**Re: Chase Bank**  
**11004 Montgomery Blvd NE**  
**Traffic Circulation Layout**  
Engineer's Stamp 05-19-2021 (G21-D018A)

Based upon the information provided in your submittal received 05-19-2021, the above referenced plan cannot be approved for Building Permit until the following comments are addressed:

SITE PLAN

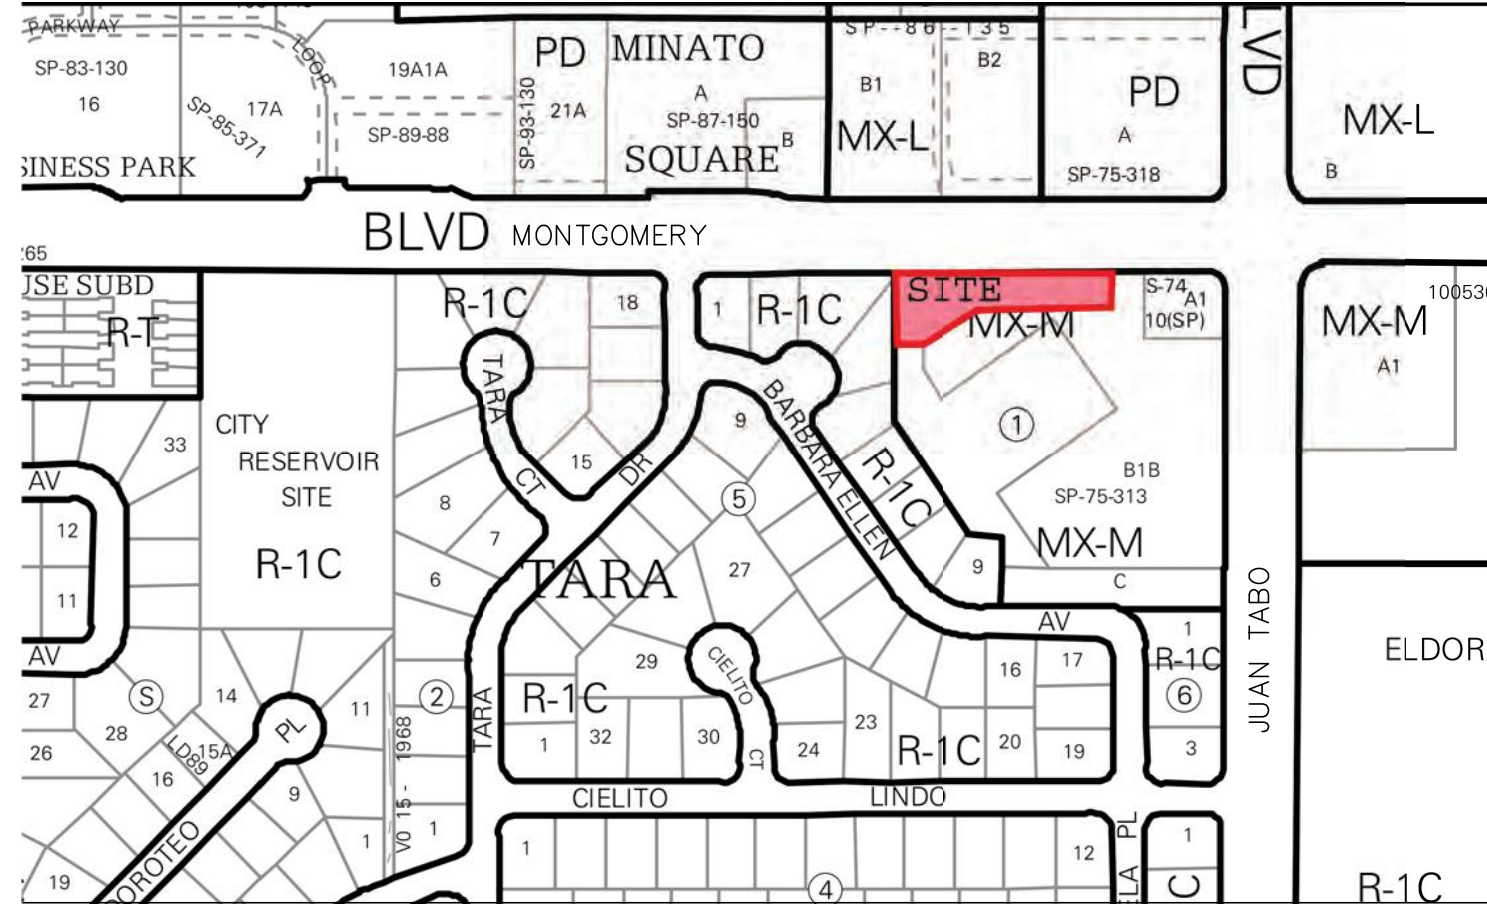
15. Bicycle parking spaces shall be at least 6 feet long and 2 feet wide.
16. Show all drive aisle widths and radii. Some dimensions are not shown.
17. The minimum drive aisle dimensions are shown below

18. List radii for all curves shown; for passenger vehicles. **Radius** for delivery trucks, fire trucks, etc. is 25 ft. or larger.
19. Per the IDO, a 6 ft. wide **ADA accessible** pedestrian pathway is required from the public sidewalk to the building entrances. **Please clearly show this pathway and provide details.**

21. **Refuse Container/Dumpster:** The container needs to be located on Chase Banks property and not adjacent property or provide approval from Land owner for permission to have existing condition mandate.

22. It is not apparent what type of pavement surface is being proposed. A hard driving surface will be required as part of this proposed project for parking area and drive aisles. **Provide surface design for parking lot.**

23. Provide existing sidewalk widths on public street frontage.
24. Clear sight distance exhibit doesn't function since its location/placement is on the ingress lane. Instead provide a stopping sight distance exhibit on the egress lane.

30. Note B: Verify that 5 ft is sufficient width of proposed sidewalk segment. Otherwords, match what is existing on Montgomery Blvd sidewalk width. Note B ,proposed 5 ft sidewalk and existing sidewalk/ADA ramp don't line up. Modify island and note B to line up across all islands and both sides of the approach and departure of sidewalk, ADA ramp and sidewalk infrastructure.

31. **Add a note stating "All broken or cracked sidewalk must be replaced with sidewalk and curb & gutter." A build note must be provided referring to the appropriate City Standard drawing (2430 & 2415A).**

MOTORCYCLE
PARKING SIGN
N.T.S.

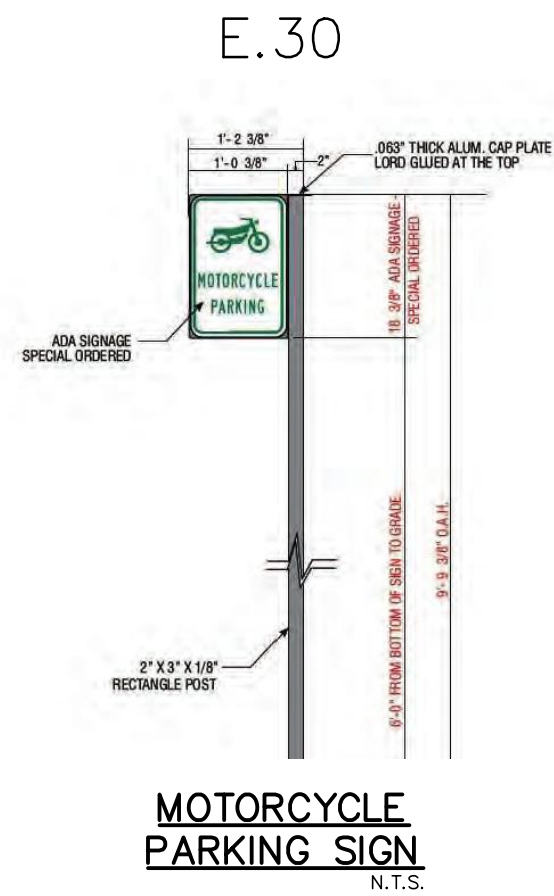
11. Motorcycle parking spaces shall be designated by its own conspicuously posted upright sign, either free-standing or wall mounted per the zoning code. **Provide sign face detail for proposed sign.**

ADA SIGNAGE FOR VAN
ACCESSIBLE SPACES
N.T.S.

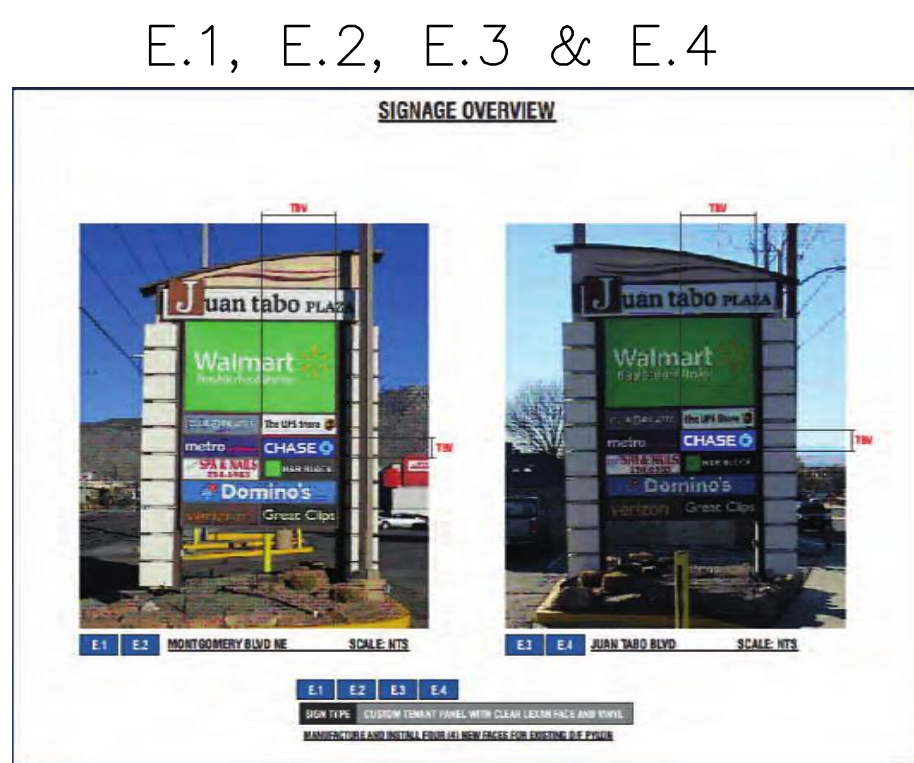
8. The ADA accessible parking sign must have the required language per 66-7-352.4C NMSA 1978 **"Violators Are Subject to a Fine and/or Towing."** Please call out detail and location of signs.

ADA RAMP DETAIL
N.T.S.

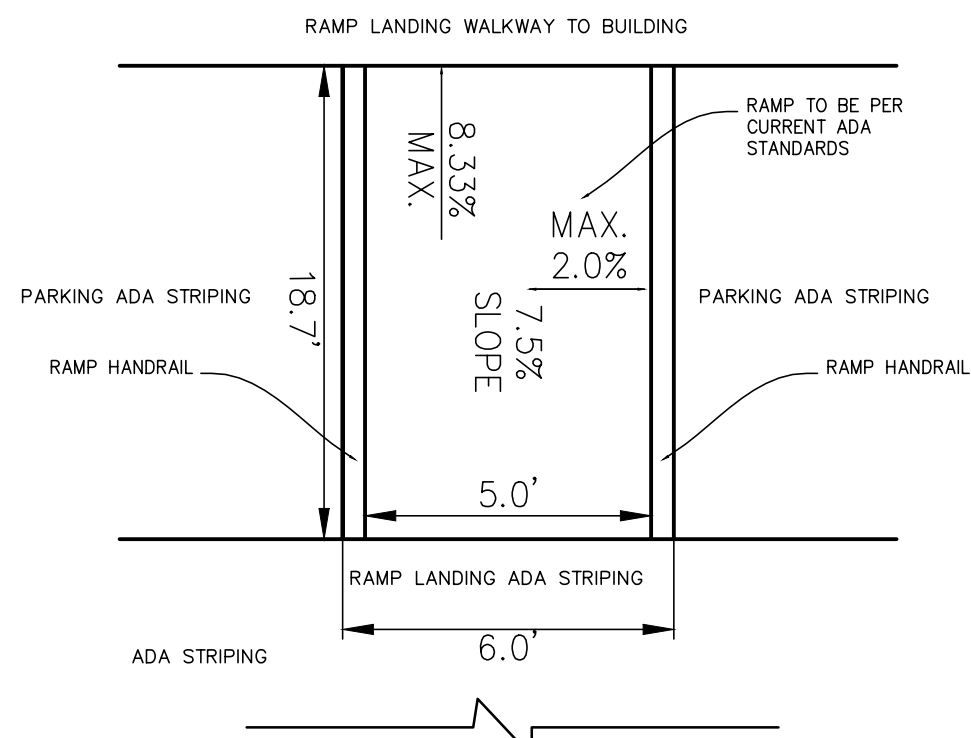
9. ADA curb ramps must be updated to current standards and have truncated domes installed (**Montgomery Blvd frontage/entrance**).
10. Please provide an over all details/full segment of proposed handrails (**Needs to follow ADA Accessible Guidelines**).

BICYCLE RACK DETAIL
N.T.S.

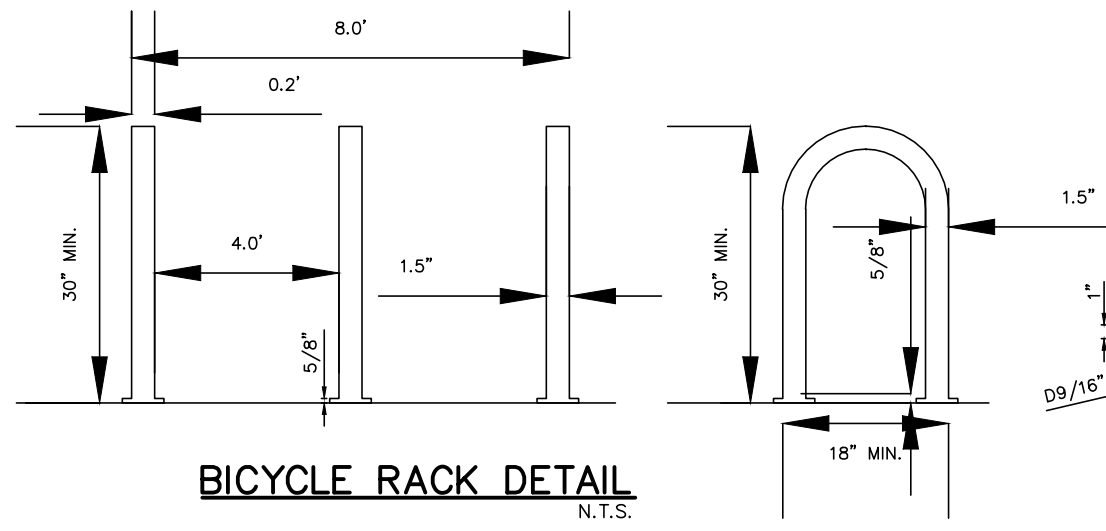
12. All bicycle racks shall be designed according to the following guidelines(**IF APPLICABLE**):
  - a. The rack shall be a minimum 30 inches tall and 18 inches wide.

- b. The bicycle frame shall be supported horizontally at two or more places. Comb/toaster racks are not allowed.
  - c. The rack shall be designed to support the bicycle in an upright position. See the IDO for additional information.

- d. The rack allows varying bicycle frame sizes and styles to be attached.
  - e. The user is not required to lift the bicycle onto the bicycle rack.

- f. Each bicycle parking space is accessible without moving another bicycle.
13. Bicycle racks shall be sturdy and anchored to a concrete pad.
14. A 1-foot clear zone around the bicycle parking stall shall be provided.

ADA PARKING STALLS AND AISLE DETAIL
N.T.S.

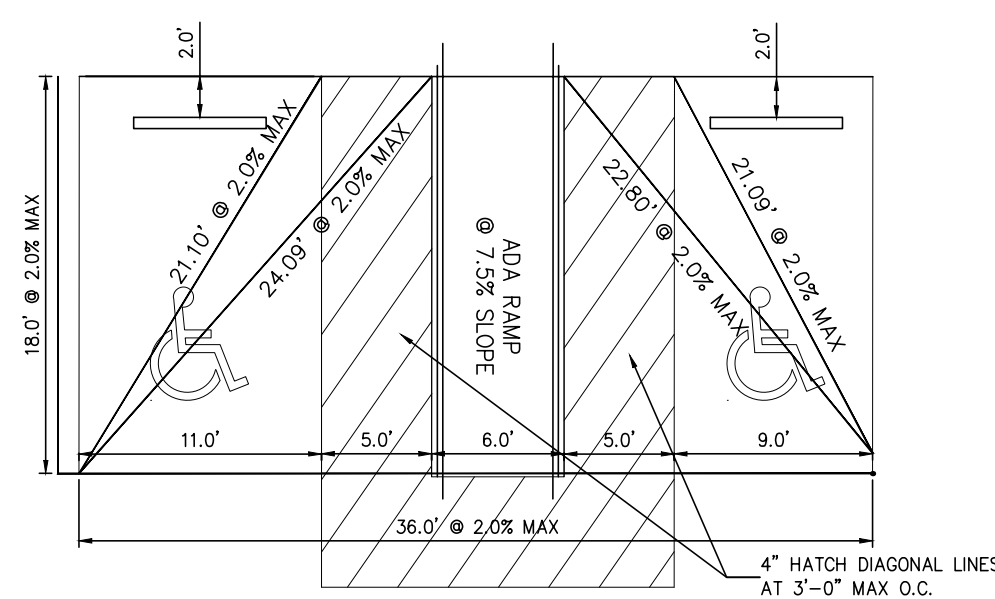
6. Montgomery entrance: The ingress and egress don't follow our guidelines. **Please adjust and/or call out discuss this traffic situation**
7. The ADA accessible spaces must include an access aisle. **Van accessible aisles should be 8ft wide**; all others should be 5ft wide.
